Please ask for: Ms Iqraa Malik
Email: iqraa.malik@terraquest.co.uk
Telephone: 01212341390
Our Ref: WA/91/20/HH
Your Ref:
Date: 7th December 2020

Application for Planning Permission for Works or Extension to a Dwelling

Development: SINGLE STOREY ADDITION, JOINT WITH ADJOINING PROPERTY PILGRIM COTTAGE
Location: Murroes Dairy Lane Walberton BN18 0PT

location plan

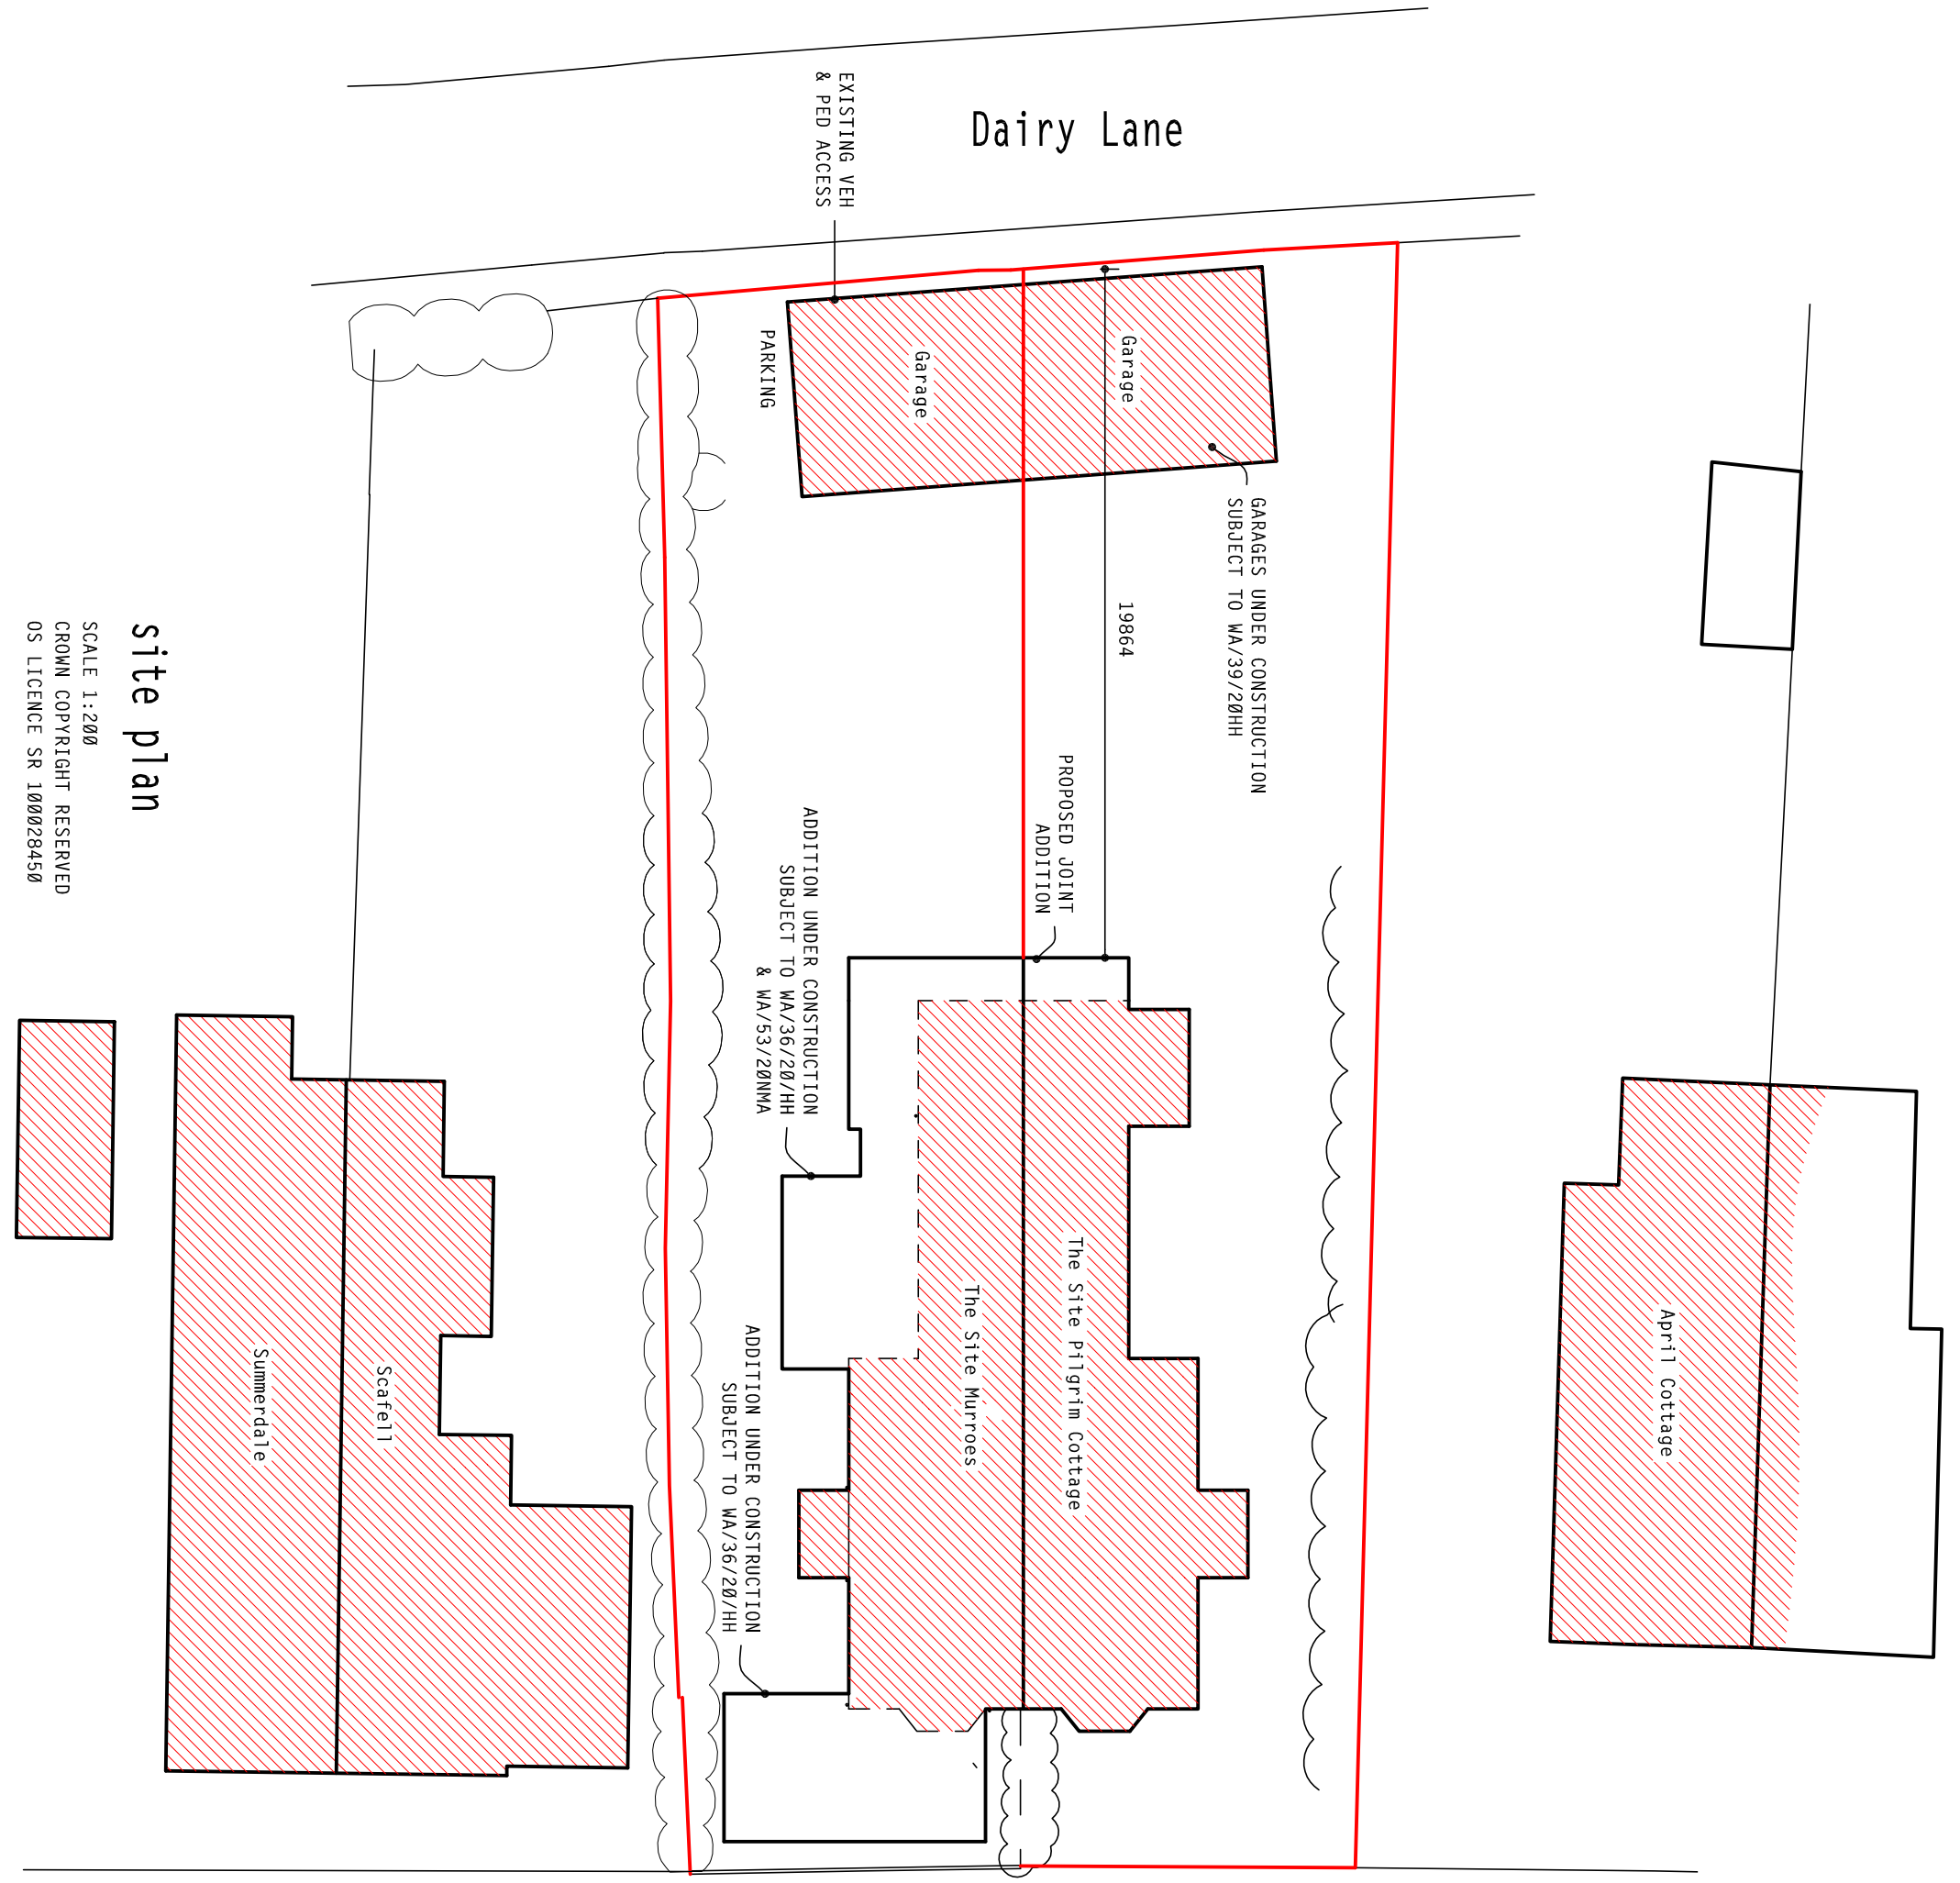
There are two site outlined in the location plan, please amend this as only the site address should be outlined in red on the location plan. Further details of what must be included on the plan can be found in the Validation Requirements List.

site plan

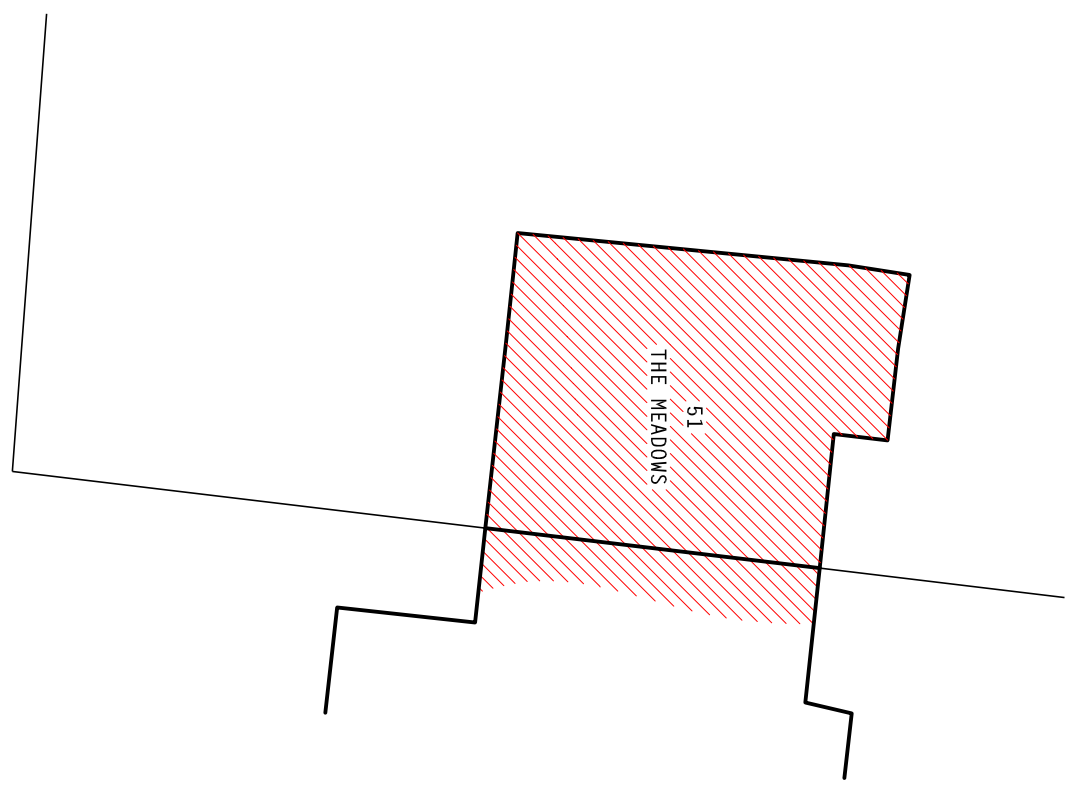
You are required to have dimensions from the proposed extension(s) to all site boundaries. Please amend.

Proposal: The plans show the proposal for two sites. Please confirm and amend as only plans for the proposed site should be shown
